## Inspector's Report ABP-304367-19

### Strategic Housing Development

472 no. residential units (234 no. houses, 238 no. apartments), crèche and all associated site works

Castletreasure/Maryborough  
(townland) Carr's Hill/Carrigaline Road  
(R609), Douglas, Co. Cork

Drawing Title
PROPOSED FOUL AND SURFACE WATER DRAINAGE LAYOUT - OVERALL

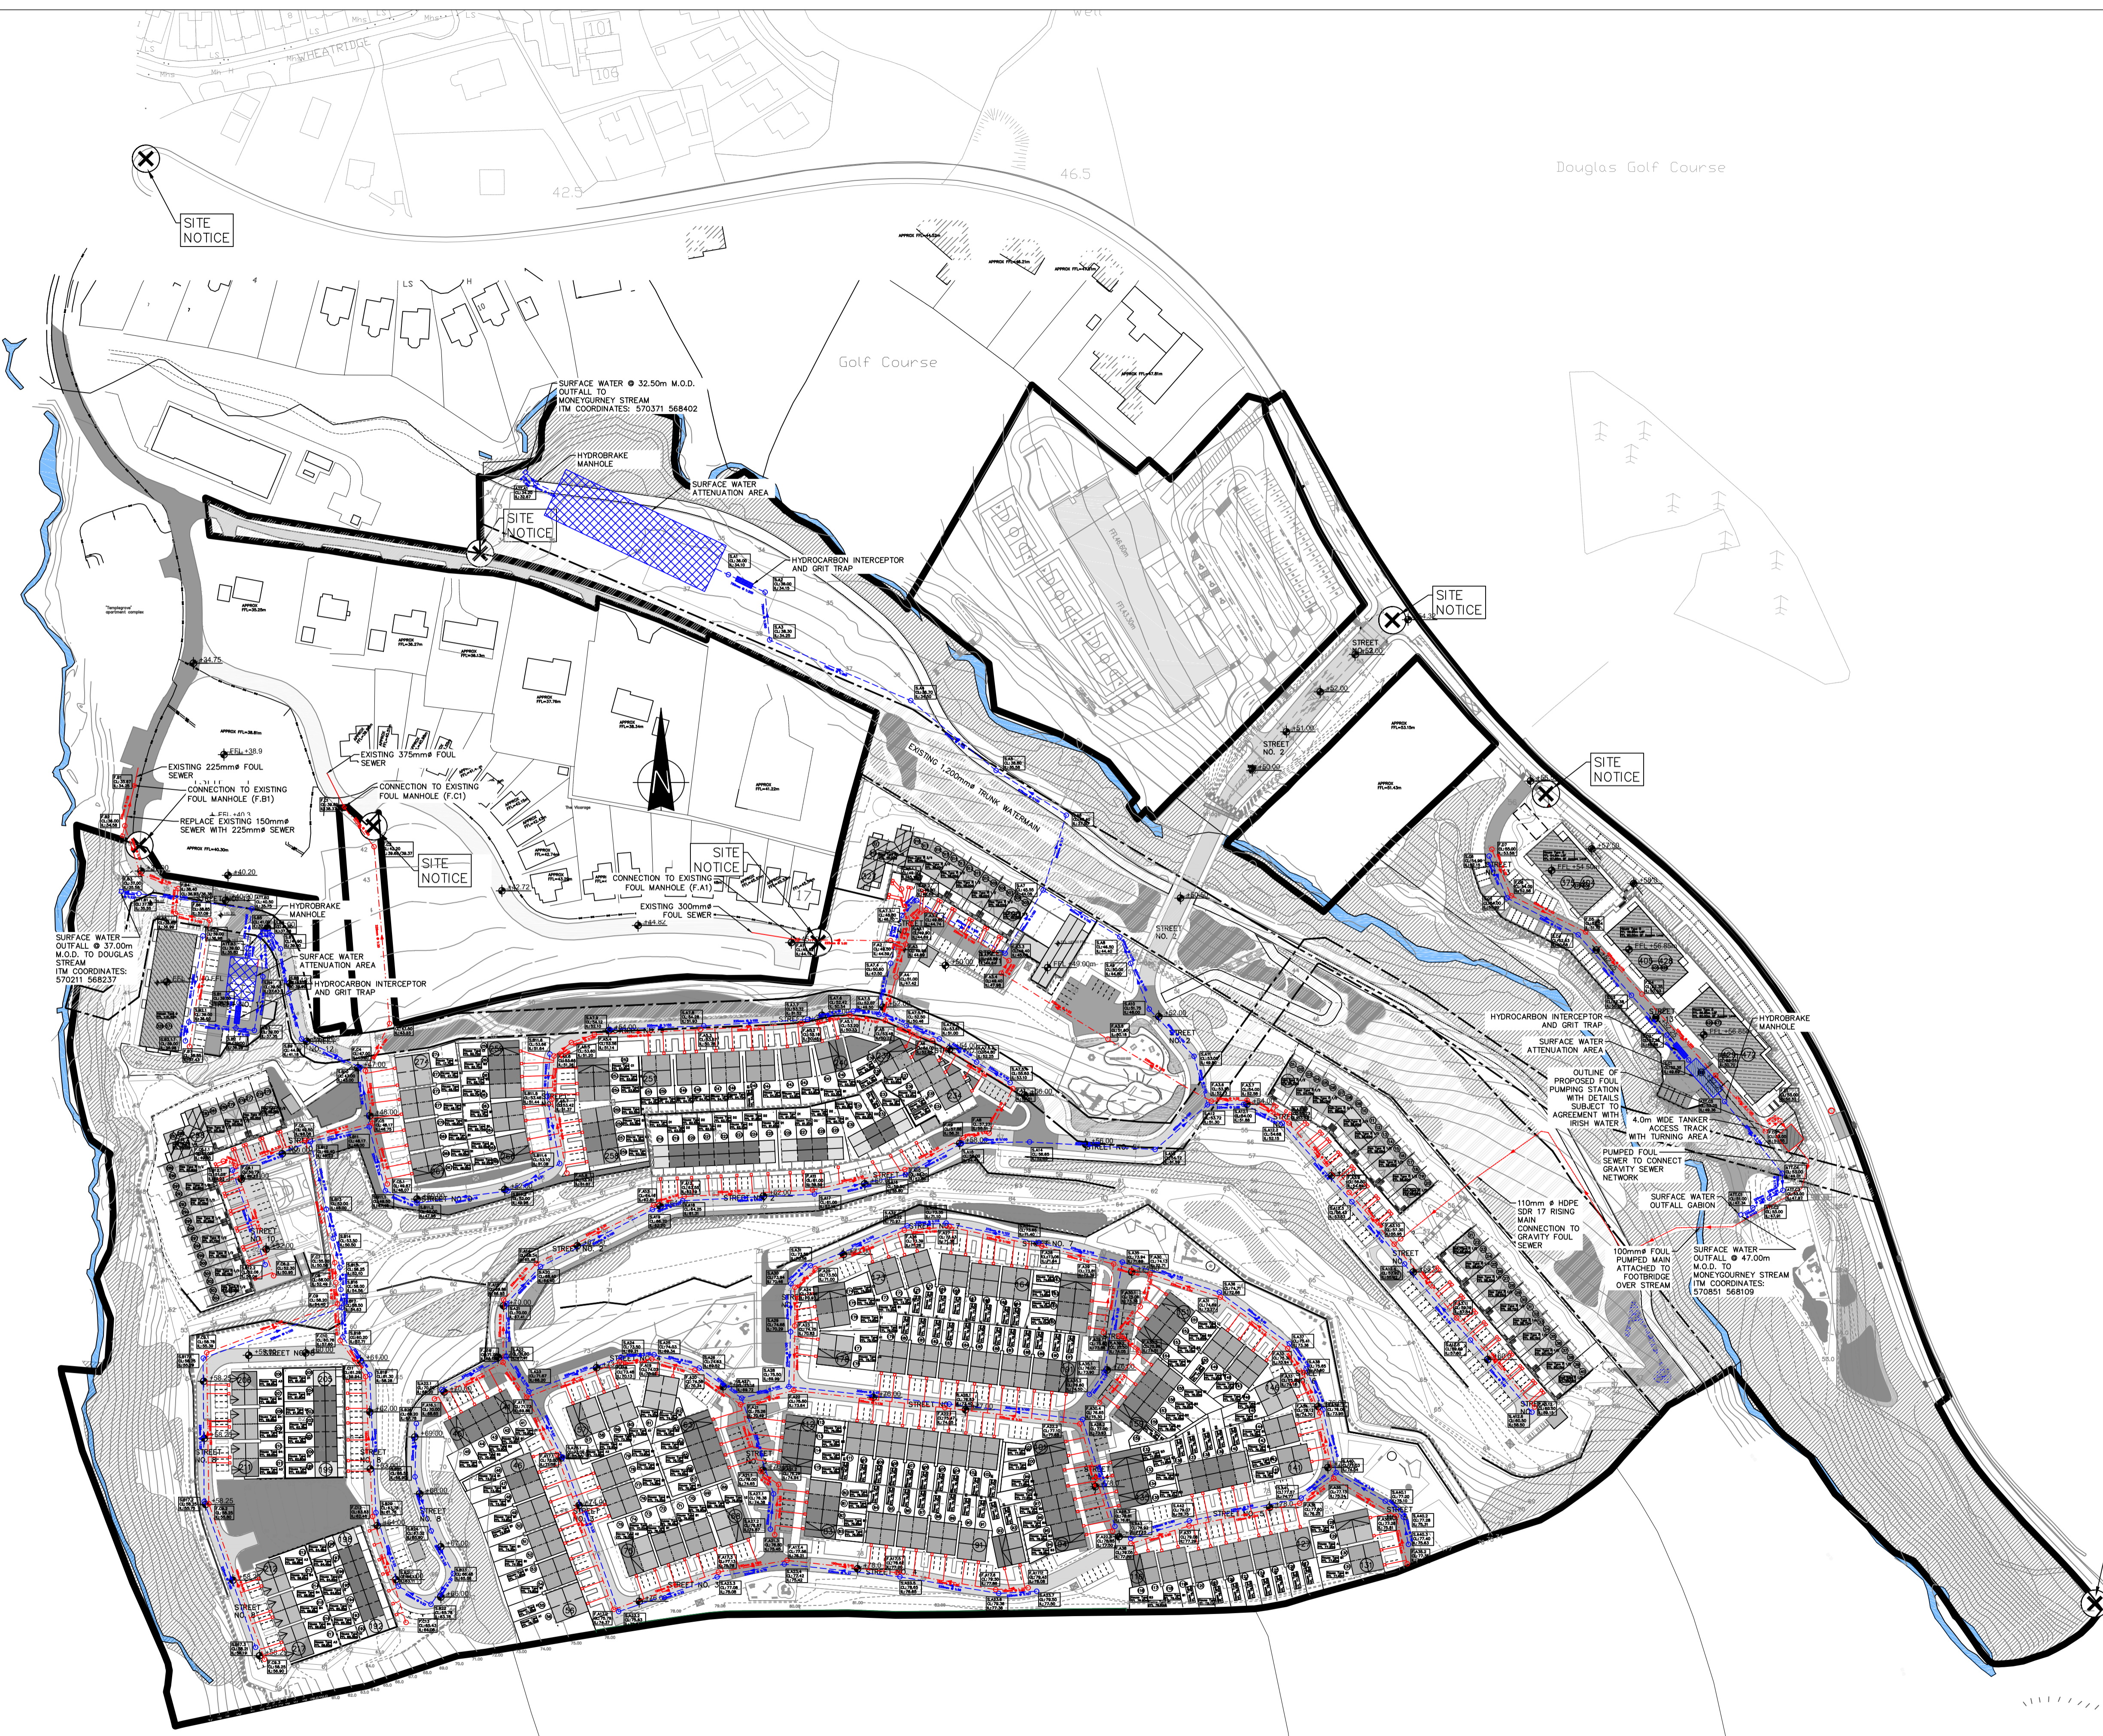
10% climate change as per the GDSDS with proposed QBAR representing a substantial reduction in the peak greenfield runoff/discharge rates from the development. The corrected attenuation storage units are indicated on the drawing titled Drainage Site Layout.

- 2.10.1. A verbal submission was made by Pádraig Sheehan. Concern was raised in relation to the outflow from the attenuation tank and where it terminates/where the outfall is as it is not clear from the drawing submitted. Concern was raised in relation to potential downstream impacts and flooding of the area and potential of flooding from the attenuation tanks.
